KIRKLEES DISTRICT COUNCIL

Planning application number 2023/90956 by P O’Kane relating to the site at the rear of Sparks Road for the erection of 5, 3 bed dwellings.

We are instructed by Heathcote Transport Limited. Please accept this letter as representations on their behalf in respect of planning application number 2023/90956 (the ‘Application’) by P O’Kane (the ‘Applicant’) relating to the site at the Rear of Sparks Road (the ‘Site’), for the erection of 5, 3 bed dwellings (the ‘Development’).

5. Proposed Highway Alterations
Scale 1:200

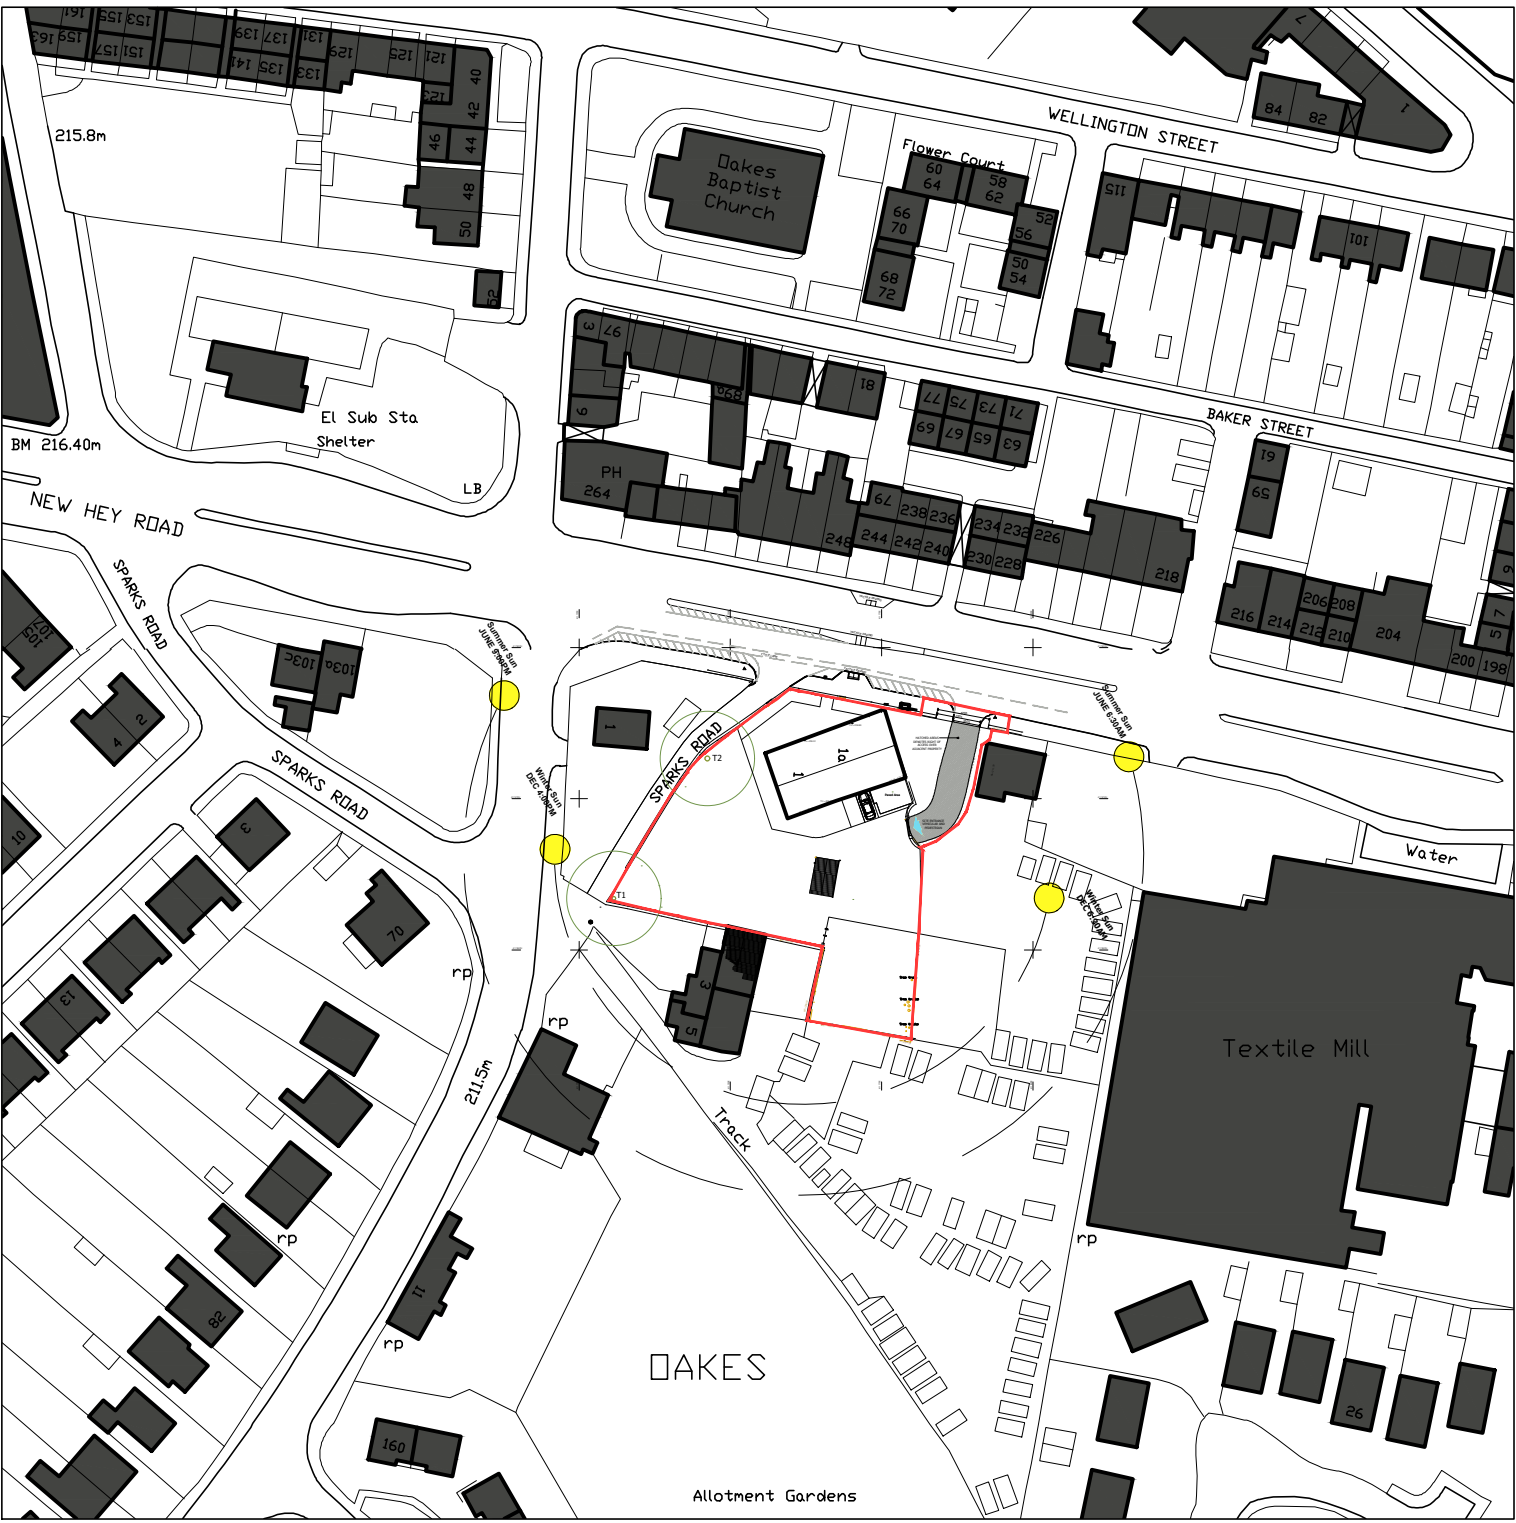
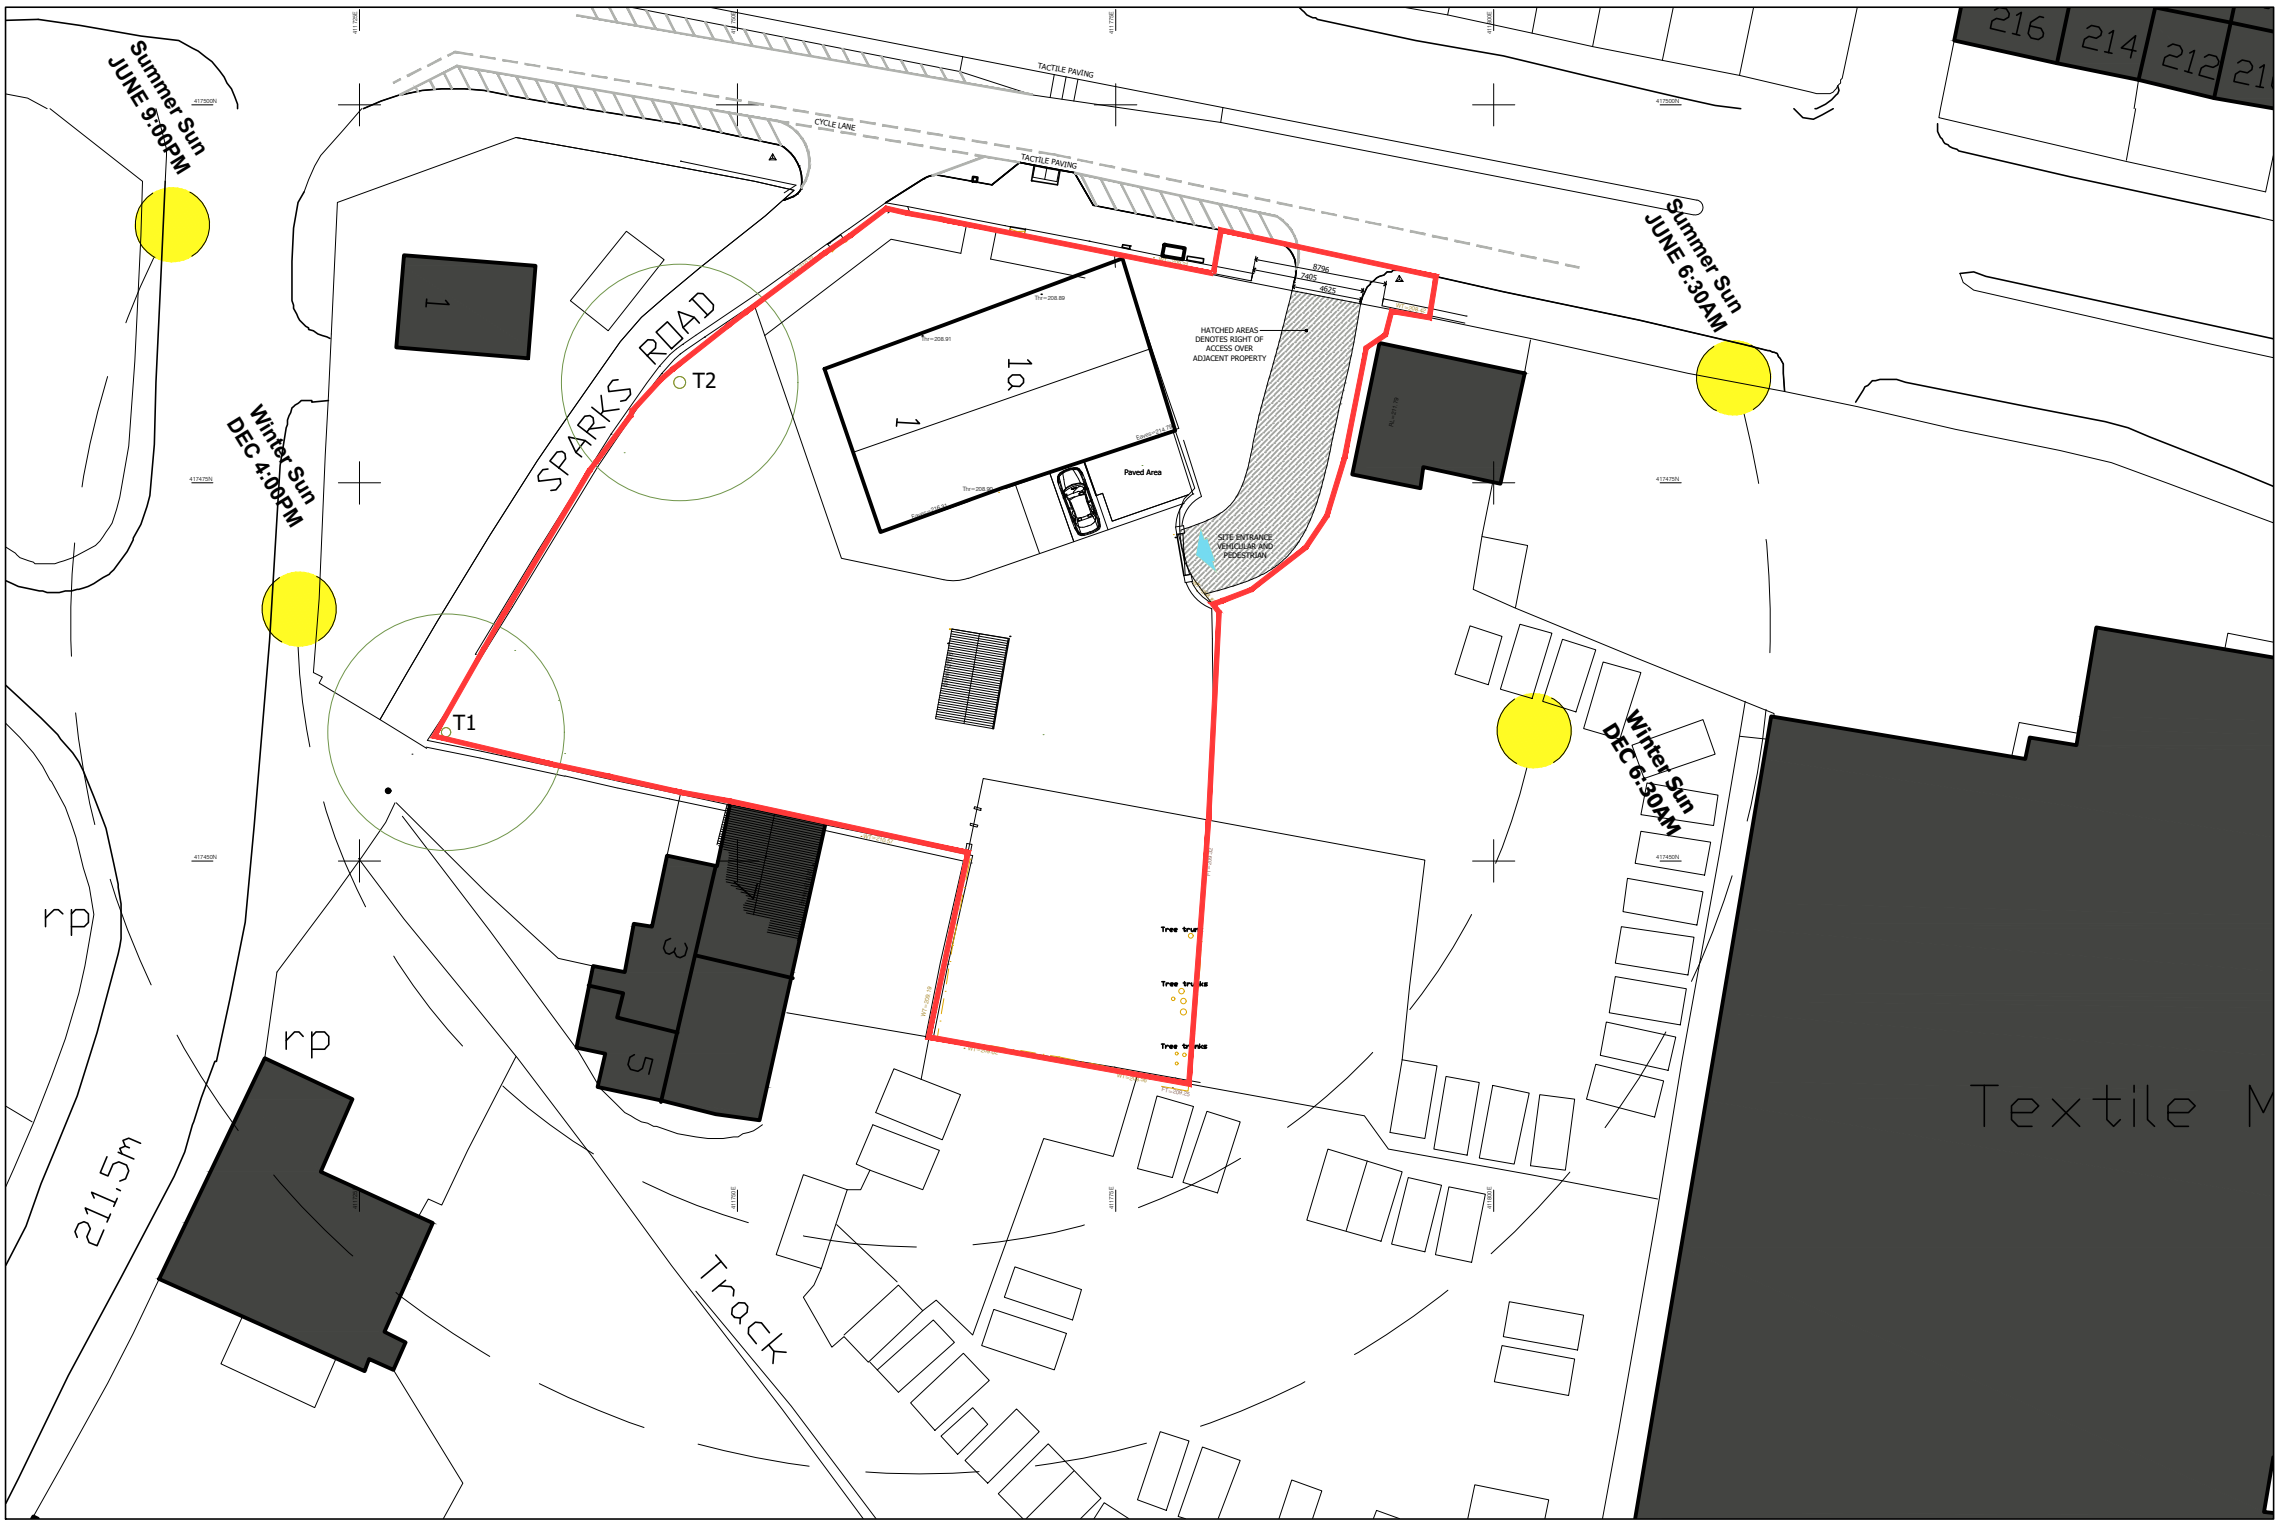
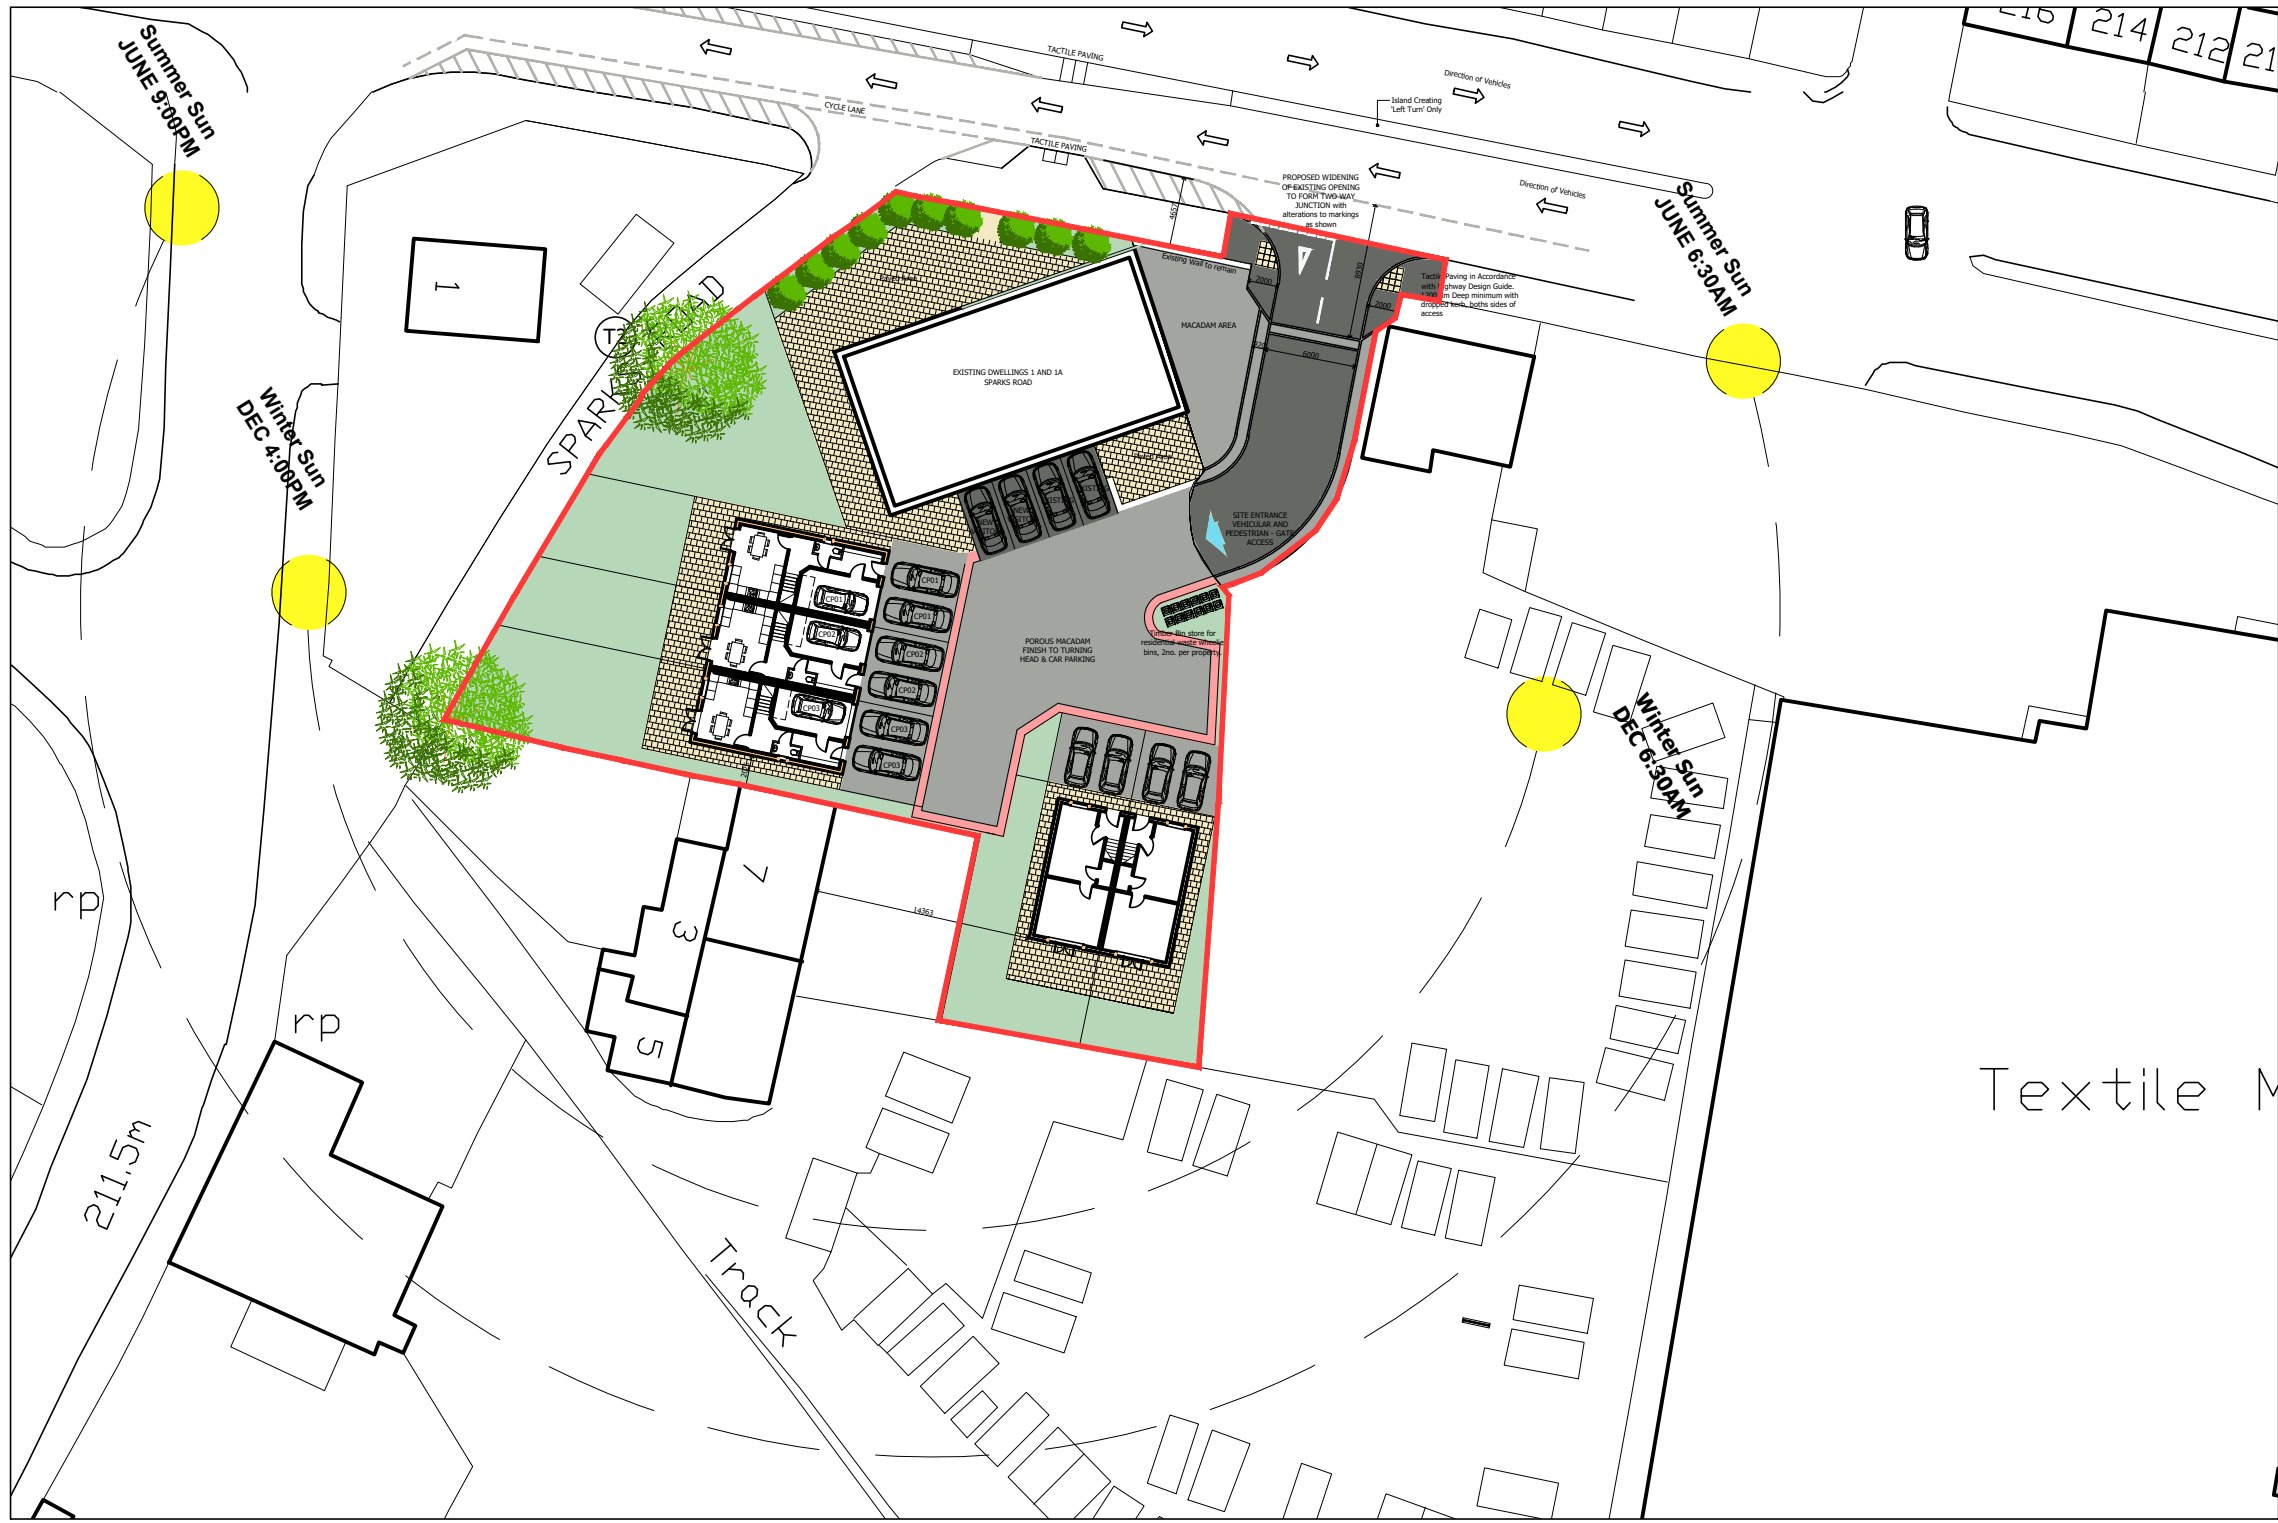
- 3.1 The Development proposes an improved junction with New Hey Road. Plan 22216.01 Rev B Nov 22 shows '*proposed widening of existing opening to form two-way*

junction'. A proposed width of the entrance at the junction with New Hey Road of 6000m with 2000mm either side is proposed and a note on the plan states '*Tactile paving in accordance with Highway Design Guide 1,200 mm. Deep minimum with dropped kerb both sides of access.*

3.2 To widen and improve the junction as proposed would require land included in the title registered to Mr [redacted] and no consent has been given or legal rights granted to allow this to happen. The Applicant cannot therefore widen the junction as proposed and for the same reasons given at 2.6 above planning permission should not be granted for this development when the Applicant does not have the right to construct the proposed junction.
